Subject: 2025/90439 Church of the Holy Innocents, Vicarage Road, Dewsbury, WF12 9PD

2025/90439 FORMER CHURCH of HOLY INNOCENTS, DEWSBURY WF12

Matthew Saunders
ECCLESIASTICAL CASEWORKER
Historic Buildings and Places
www.hbap.org.uk
Formerly Ancient Monuments Society

Project/Client:	Project No:
Church of Holy Innocents	22-111
Vicarage Road	Dwg No:
Dewsbury, WF12 9PD	A101
	Rev:
	C
Drawing:	Scale:
G.A. Information	A/S @A1
Site Plans	Drawn By: Date:
As Existing & Proposed	RJ Jun 23
	Checked By: Date:

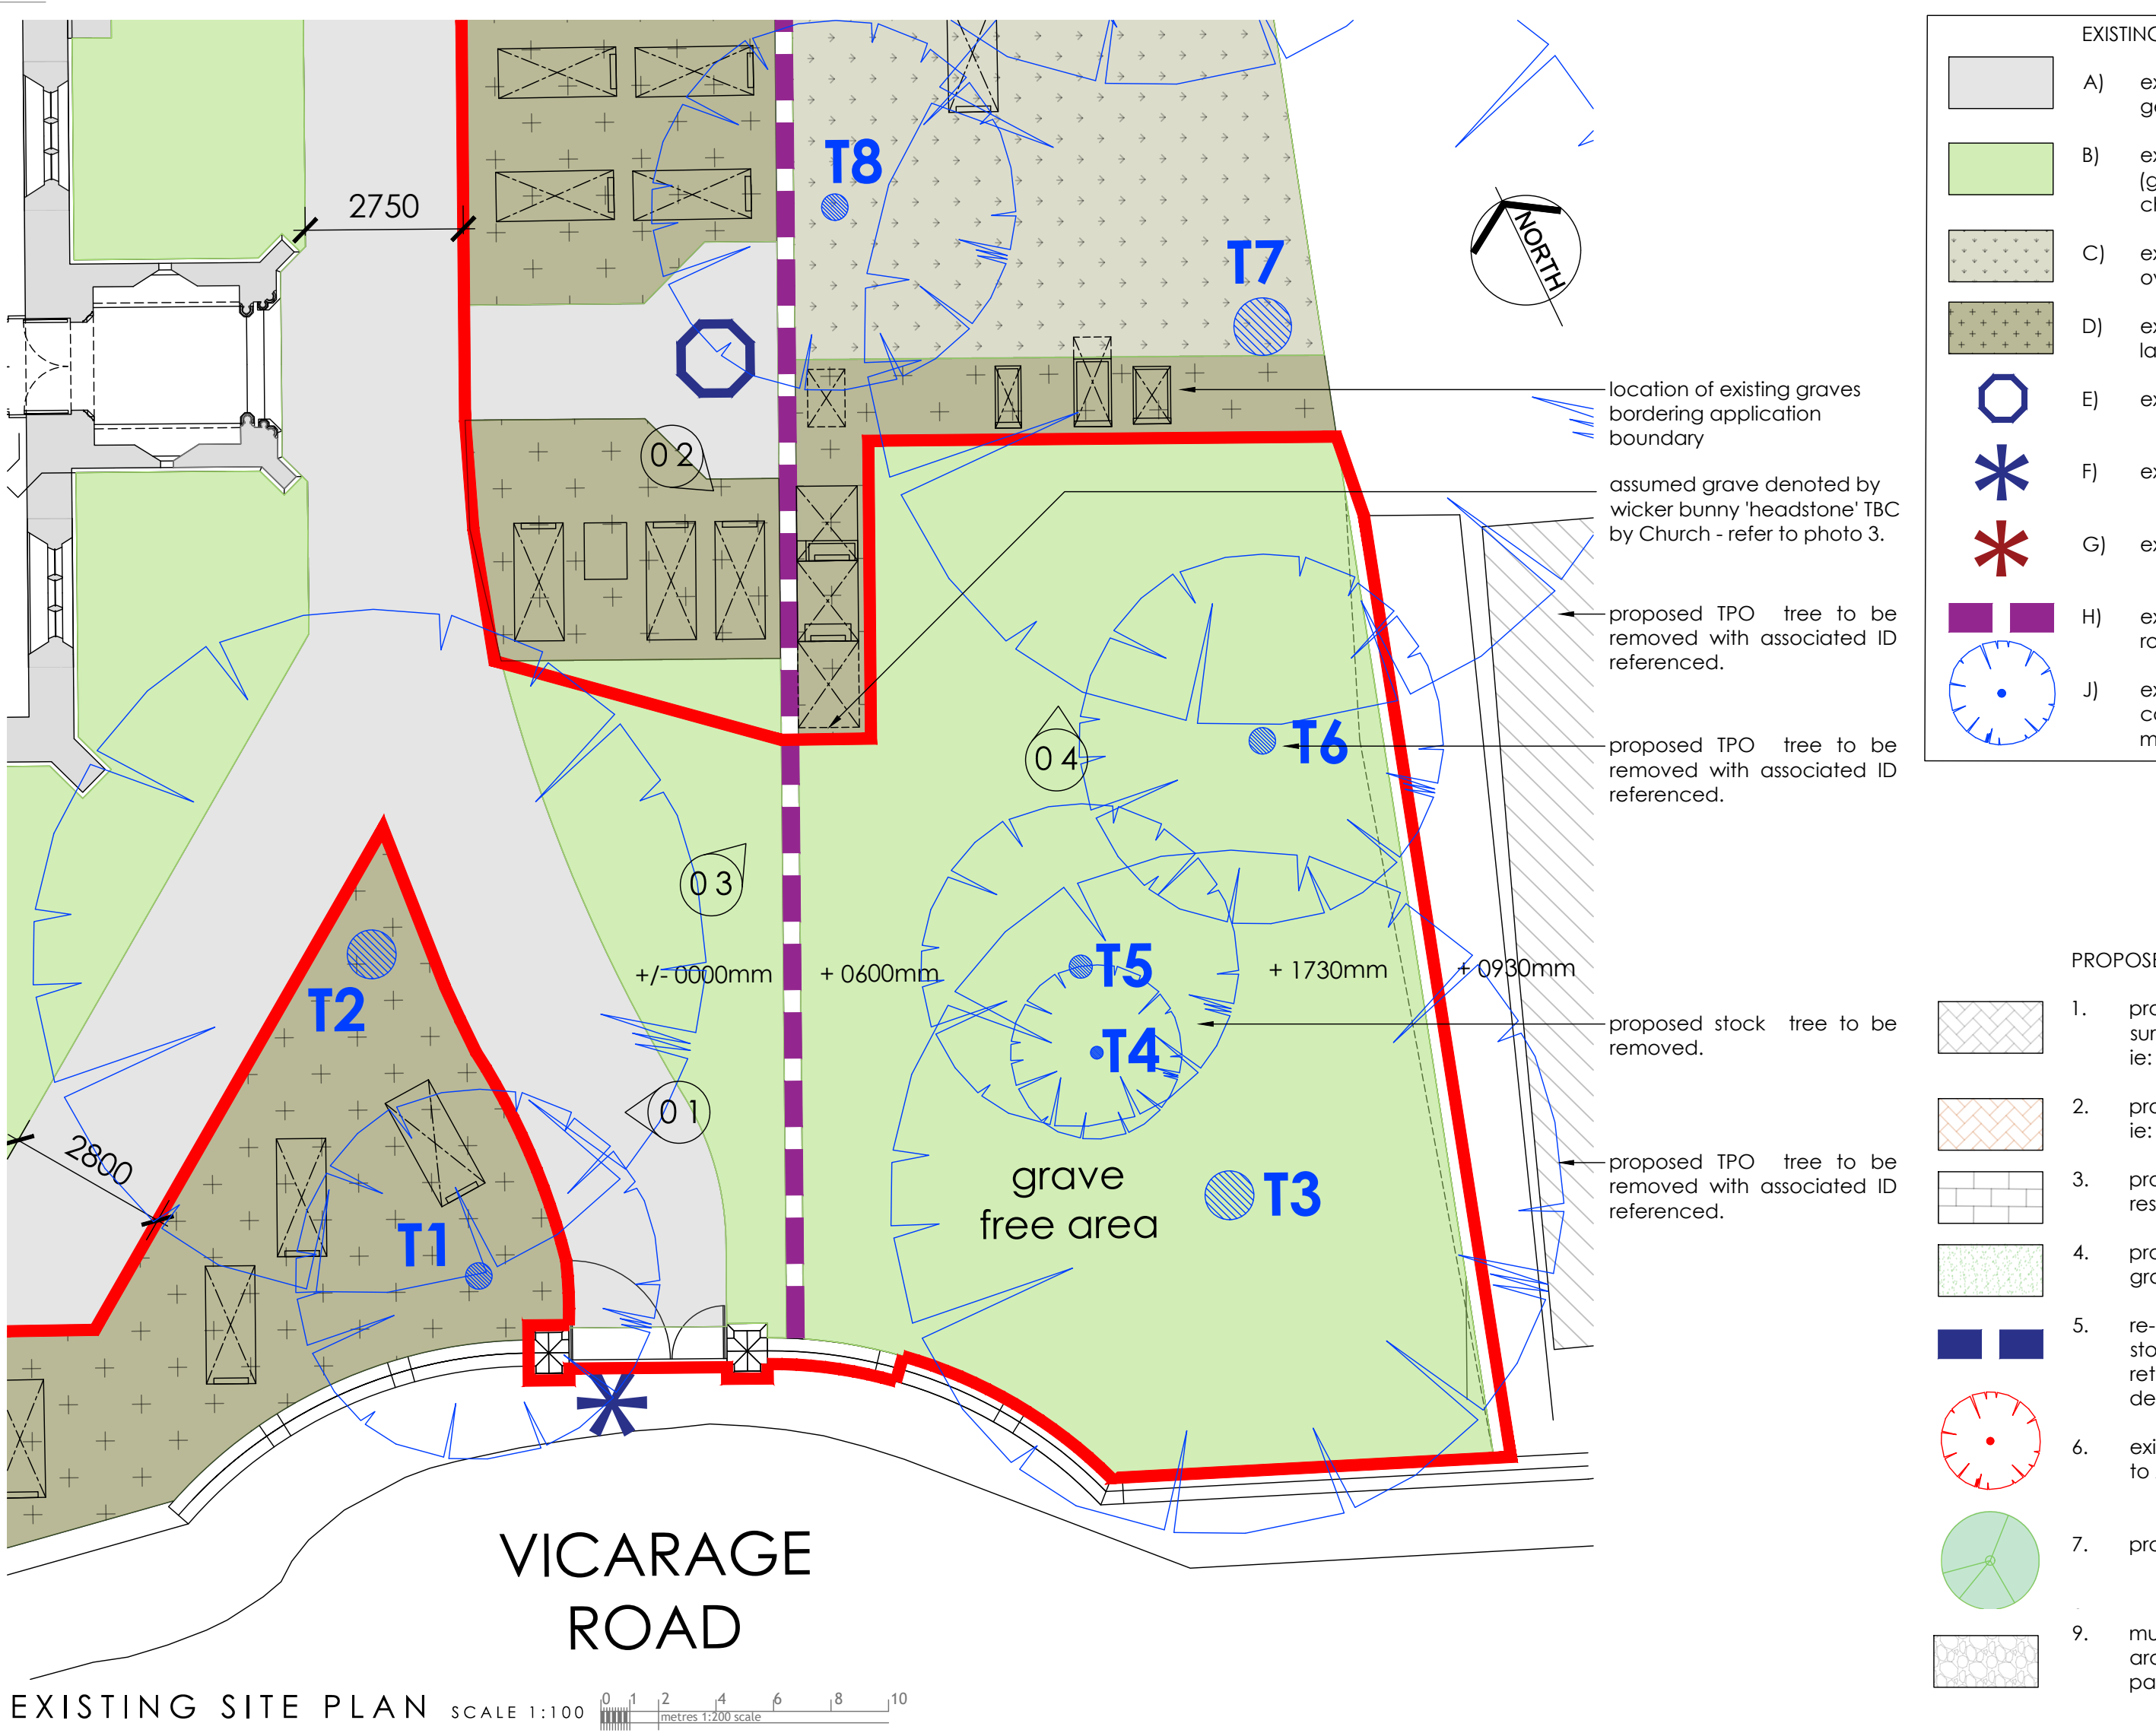
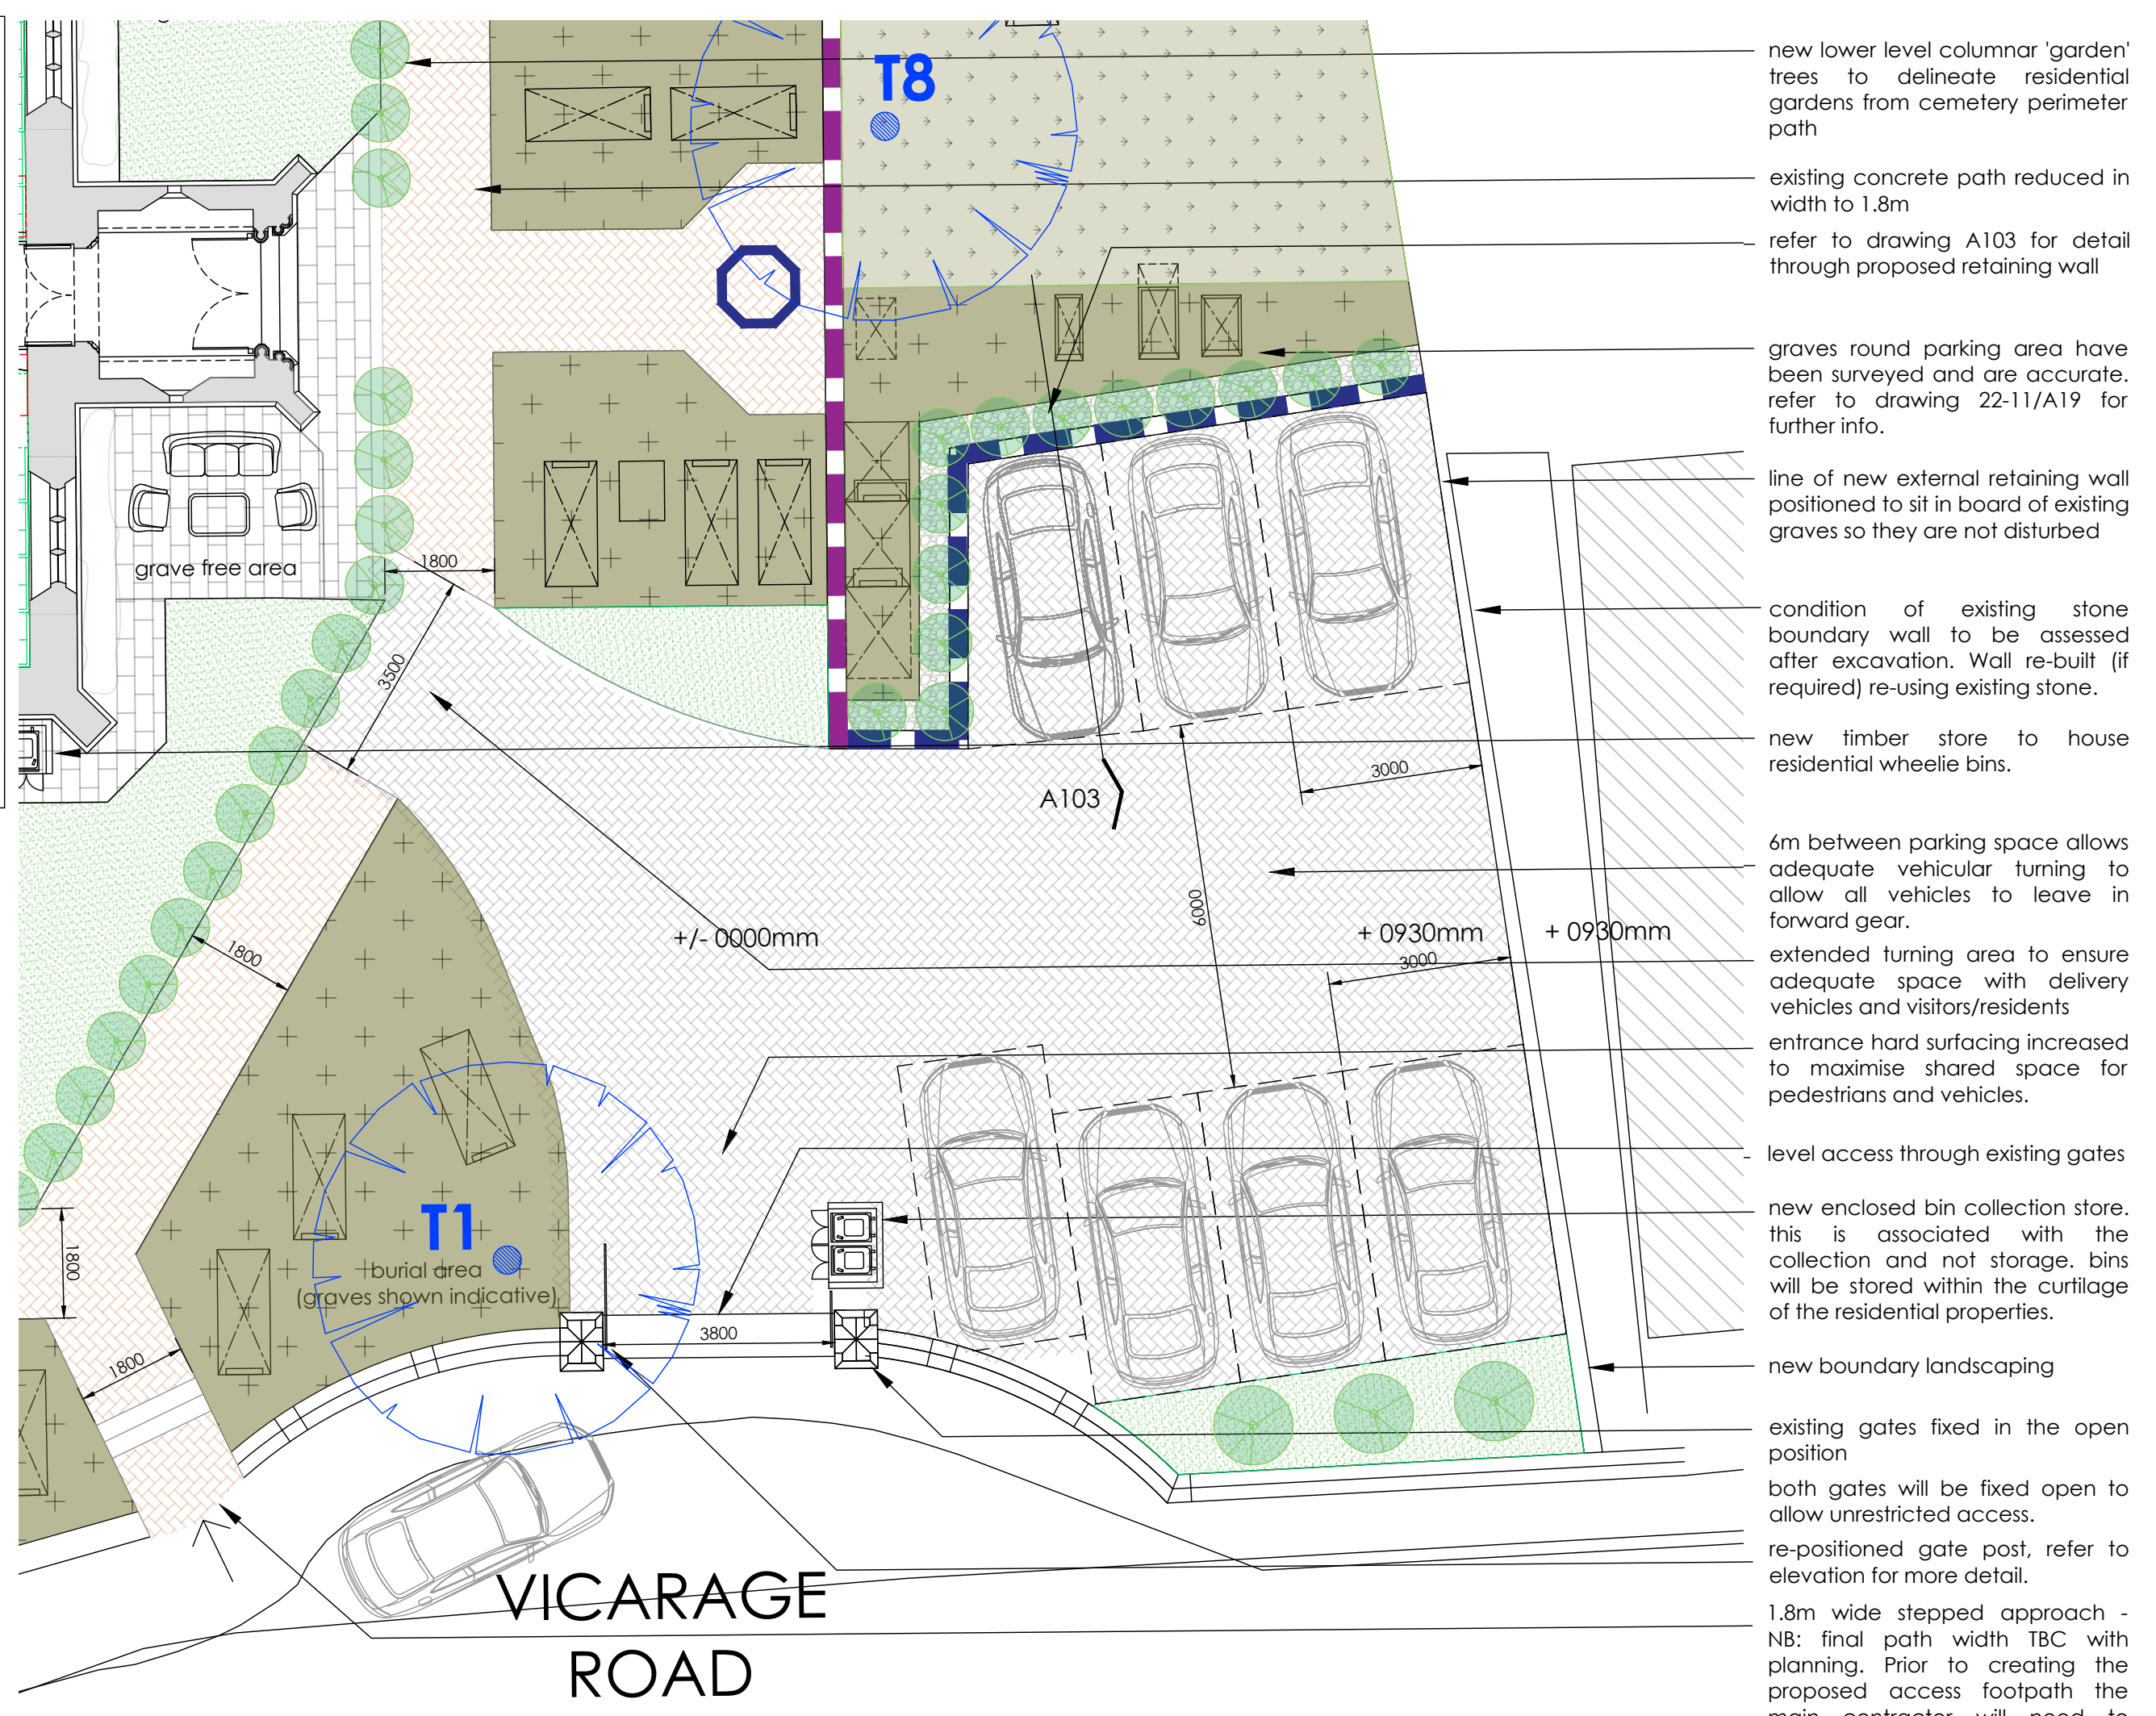
As we said above, the issue of the trees (and parking) is something for Kirklees but we would welcome as an express condition to any lbc a requirement that all headstones will stay and that, where any have to be displaced for the new parking, they will be relocated and will not be destroyed.
